The Planning Inspectorate  
National Infrastructure Planning  
Temple Quay House  
2 The Square  
Bristol  
BS1 6PN

PINS Reference EN010137 Mona Offshore Wind Farm  
Interested Party numbers MNOW-S57019 & MNOW-S57018

## **Deadline 5 Response 3<sup>rd</sup> December 2024**

Figure 1.2: Noise study area –Onshore Substation.

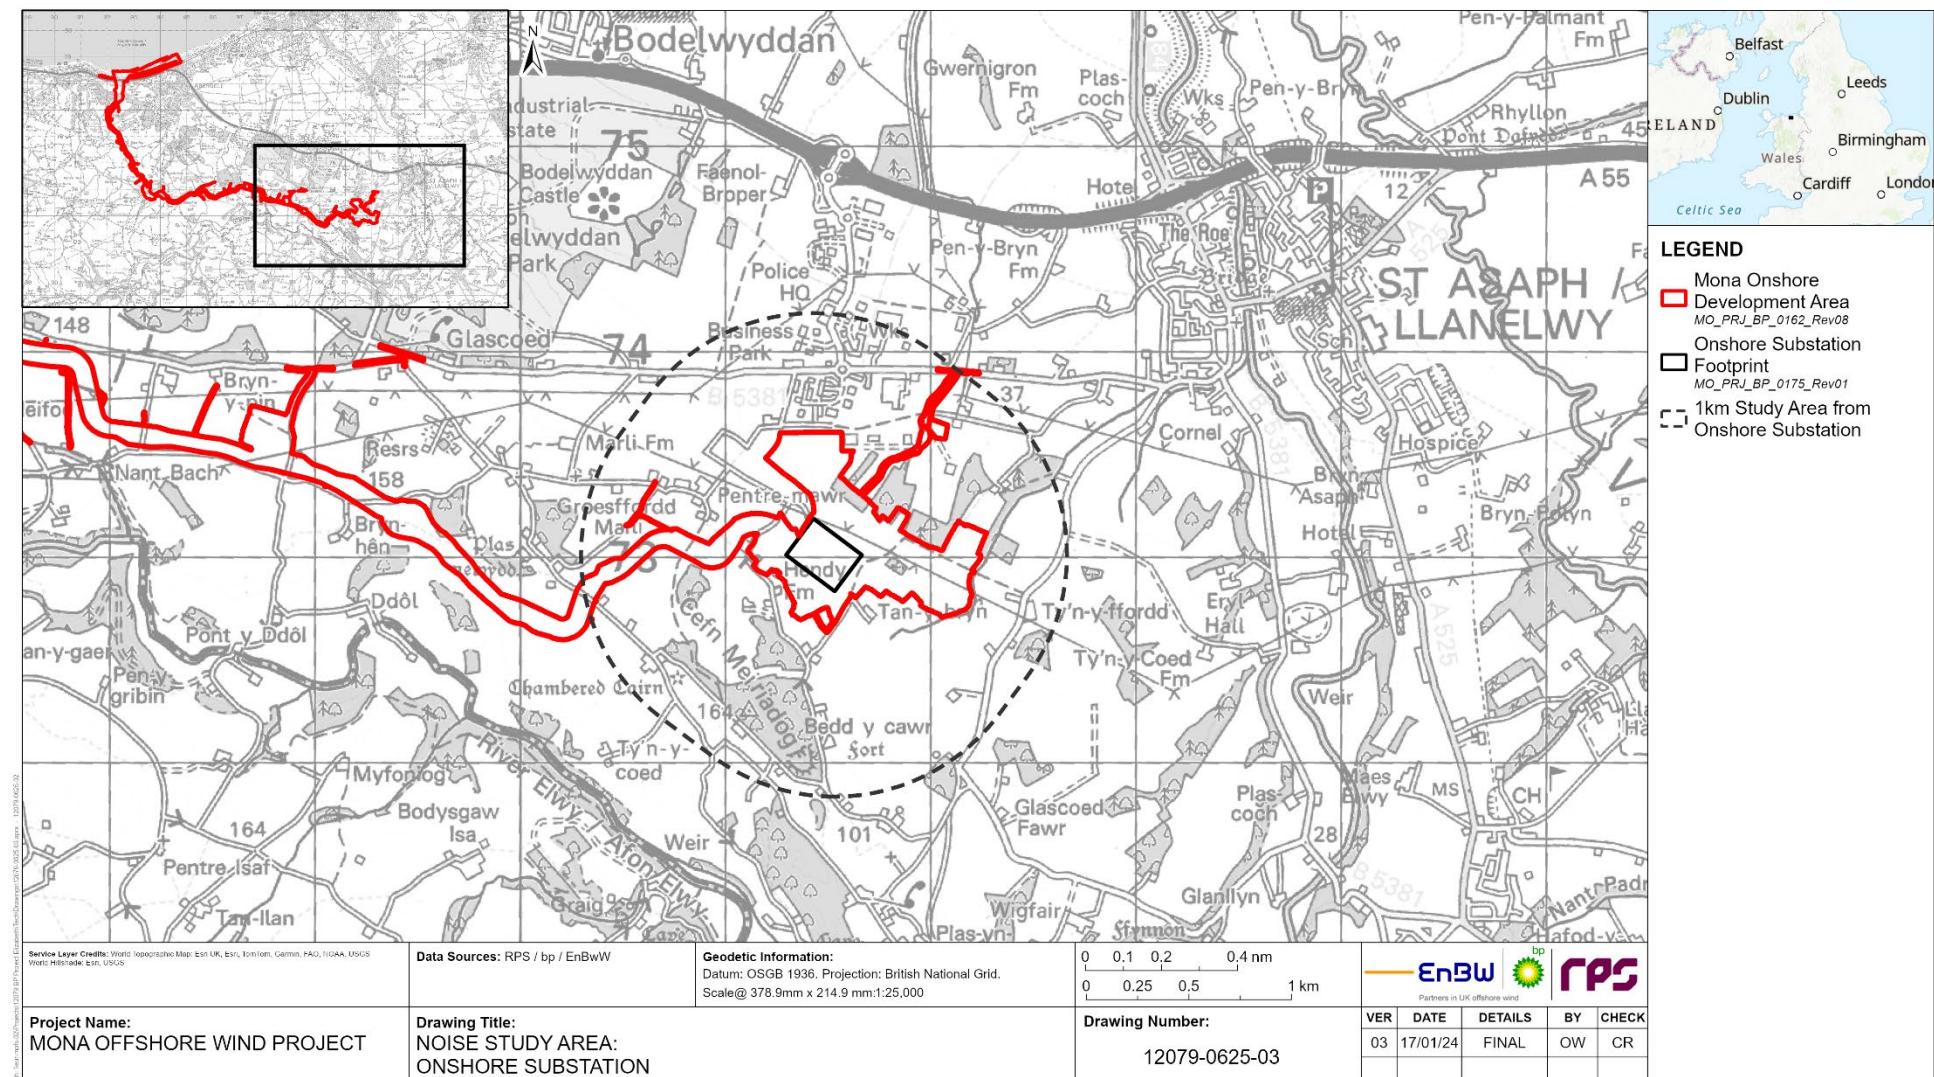
Additionally we are confused by the distance stated and used in the modelling in relation to the Substation construction activities for our property.

- REP4-045 lists 200mts as being used in the modelling.
- APP-069 Landscape and Visual section 6.5.7.6 lists the distance as 184mts
- During the site visit undertaken in October the corners of the substation platform were staked out, the stake at the South West corner is 177mts to our property. We understood from the site visit that these stakes represented the physical edge of the substation platform, therefore it would seem reasonable to assume that plant and equipment would need to operate outside the edges of the platform and so in reality be even closer.

Figure 1.6: Daytime construction noise impact magnitudes: Establish access and TCC

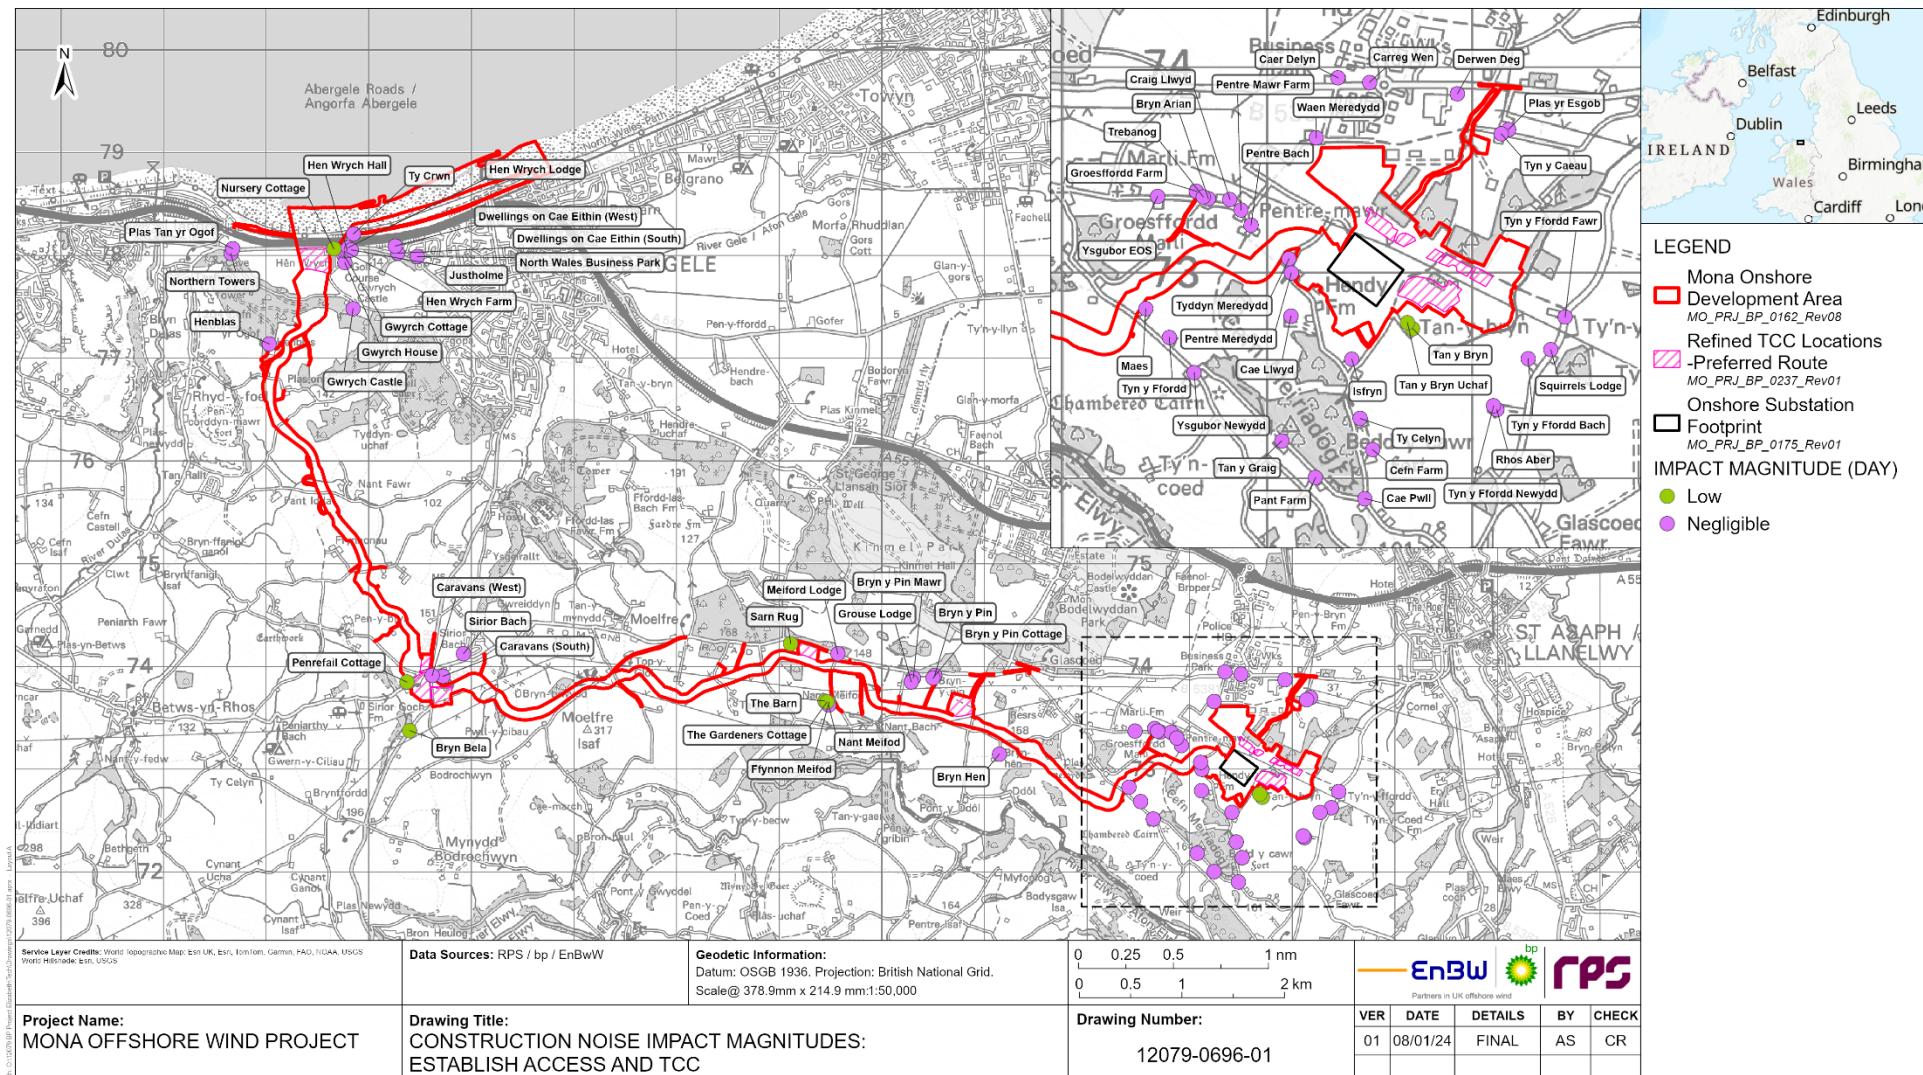
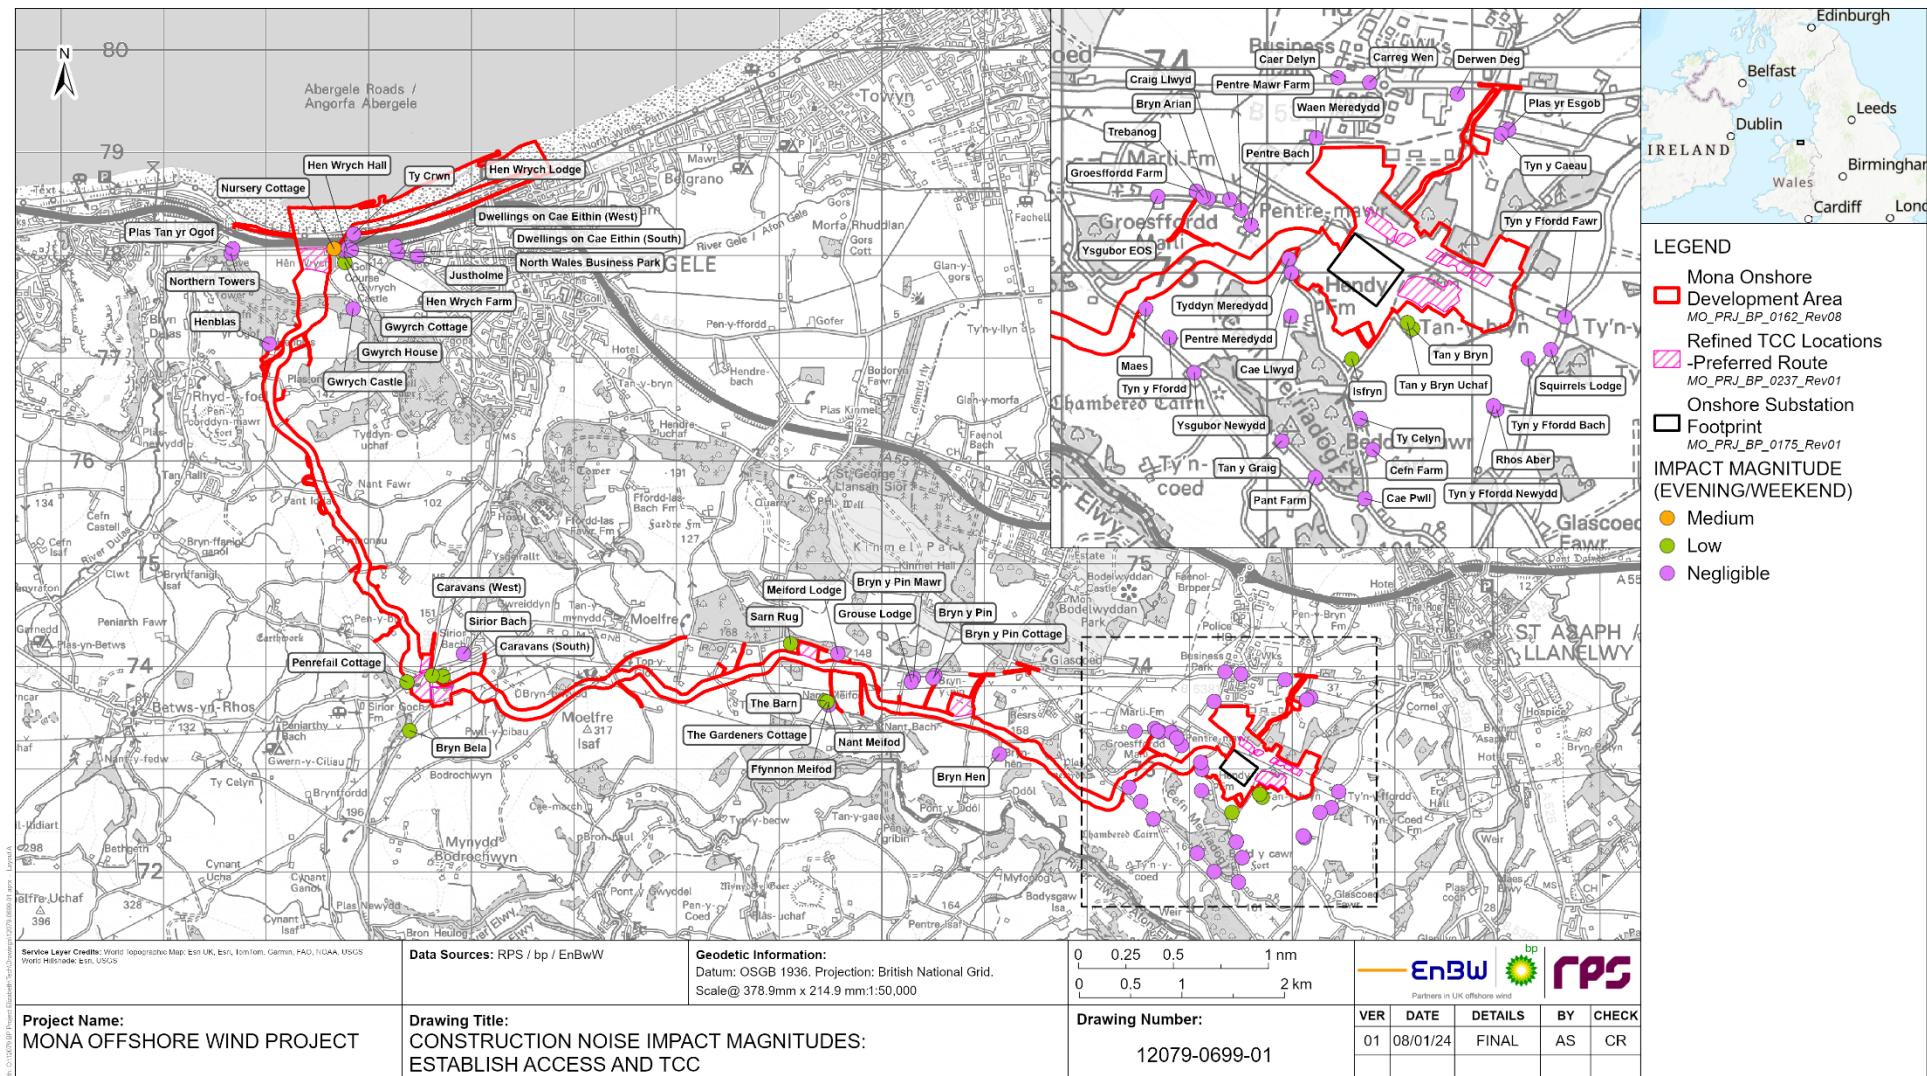
- For the establishment of Access and Temporary Construction Compounds  
Cae Llwyd has predicted noise levels of 41dB day and evenings  
Tyddyn Meredydd has predicted levels of 37dB day and evenings  
This is despite Tyddyn Meredydd reported as being 170mts closer to the activity
